Recommendation Report for Lawful Development Certificate for a Proposed Use or Development

REF NO: FP/214/18/CLP

LOCATION: 9 Alfriston Close
Felpham

PROPOSAL: Application for certificate of lawfulness for a proposed use - single storey ground extension

Existing Grounds for
Exhibition Area.
August 2018.

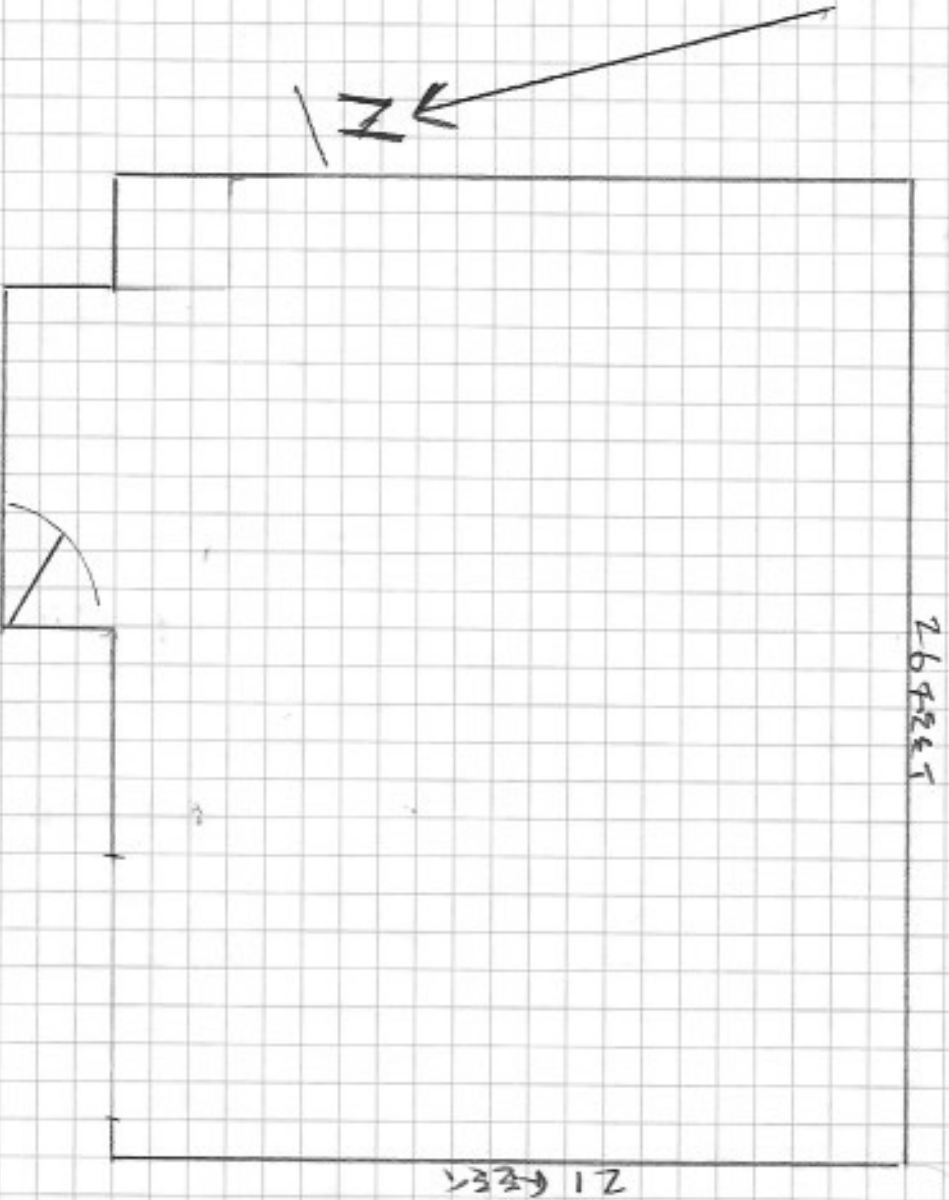
The proposed single storey extension is in conflict with Schedule 2, Part 1, Class A (e) (i) of the Town and Country (General Permitted Development) (England) Order 2015. This is because the proposed extension would extend beyond the Principle elevation. Resultantly, the proposal would require an application for planning permission.
